Planning Application AW/55/18/HH

Planning Application AW/55/18/HH for 3 The Orchard

PROPOSED ELEVATIONS

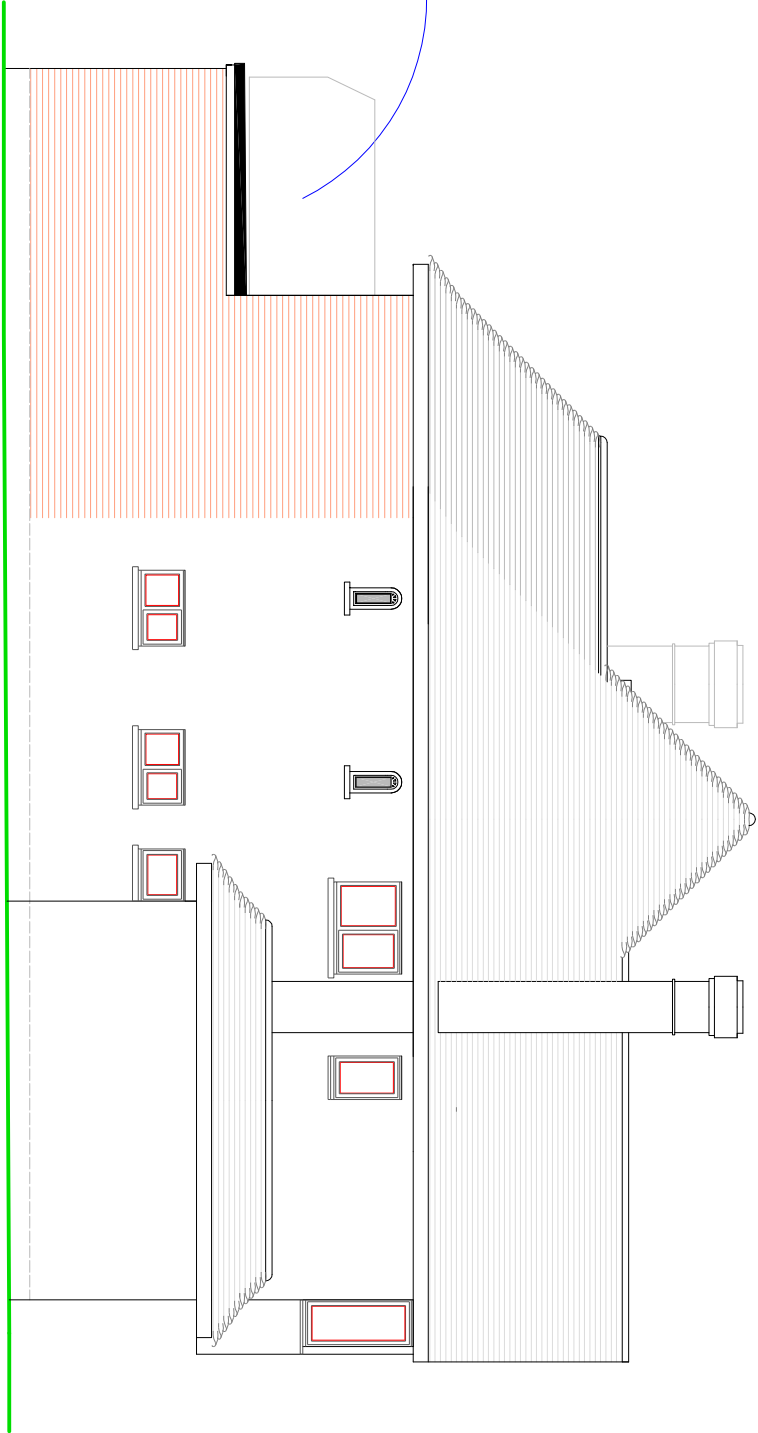
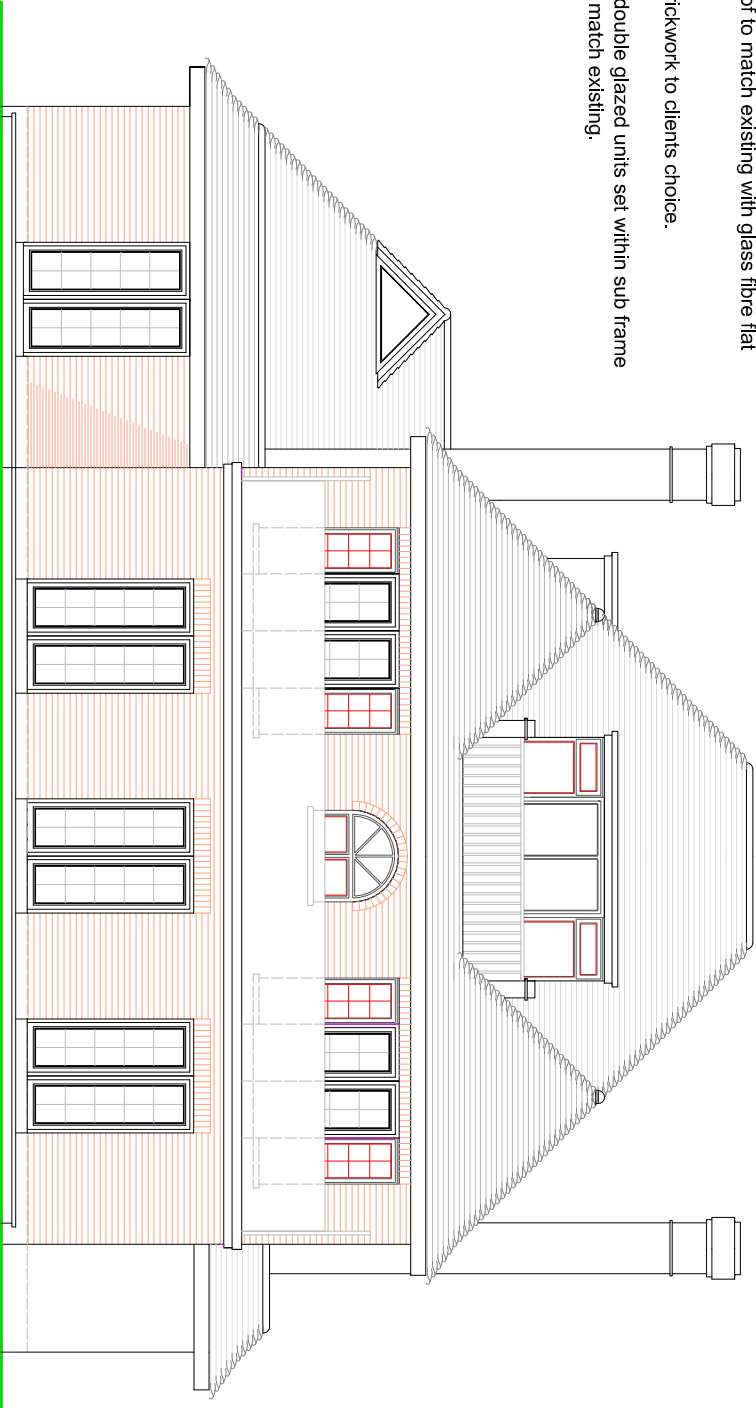
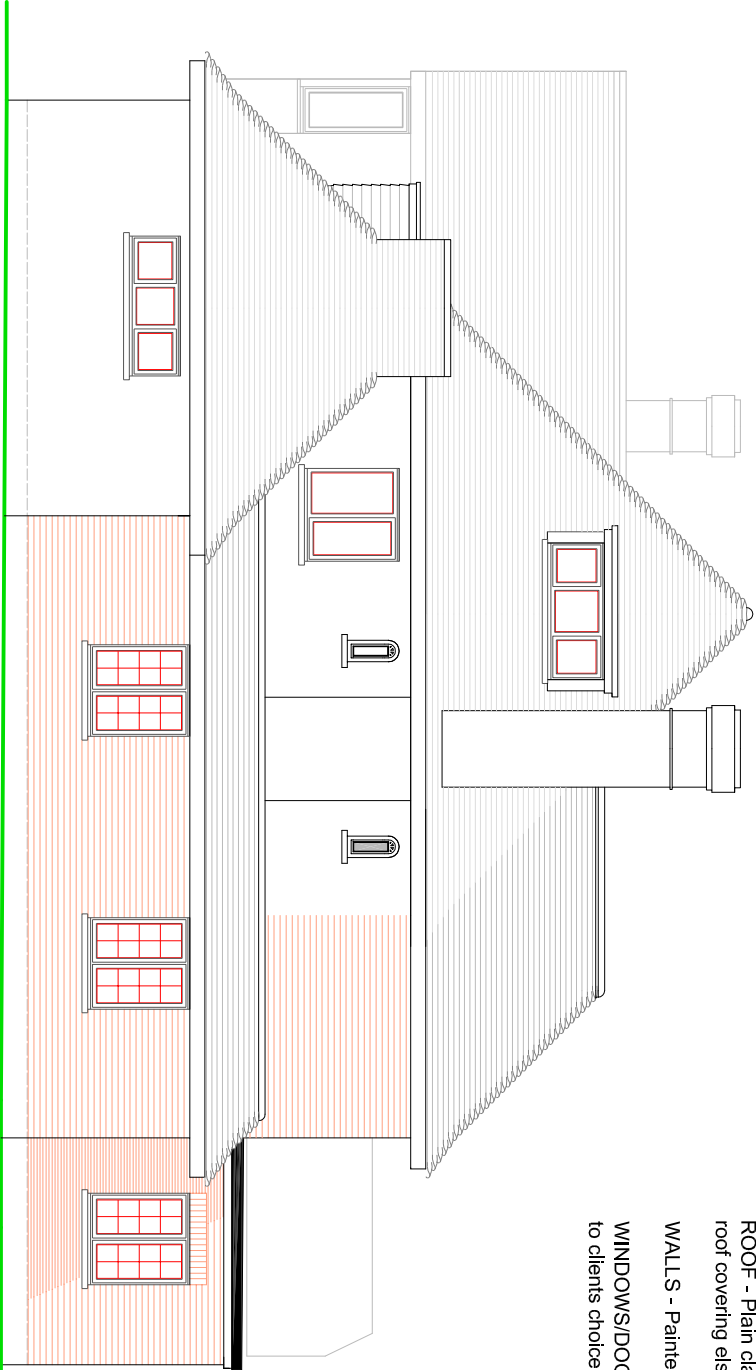
- 1) Our objection relates mainly to the proposed new balcony which constitutes a major intrusion on our privacy. Due to the angles that Nos. 2 and 3 sit at on their respective plots it will be possible for anyone using it to see directly into our upstairs study, main bedroom, sitting room and conservatory.

- 2) The proposed new balcony will totally overlook our garden.
- 3) The development is a major change in relation to the character of the rear aspects of all the other houses in The Orchard. The new balcony, in particular, with the proposed obscure glazing up to 1.7 metres will be a particularly unattractive feature and totally inconsistent with the concept of the Conservation Area.

- 4) We currently enjoy late afternoon and early evening sunlight on our patio and outside dining area particularly in spring and autumn. This extension will severely restrict the amount of sunlight.
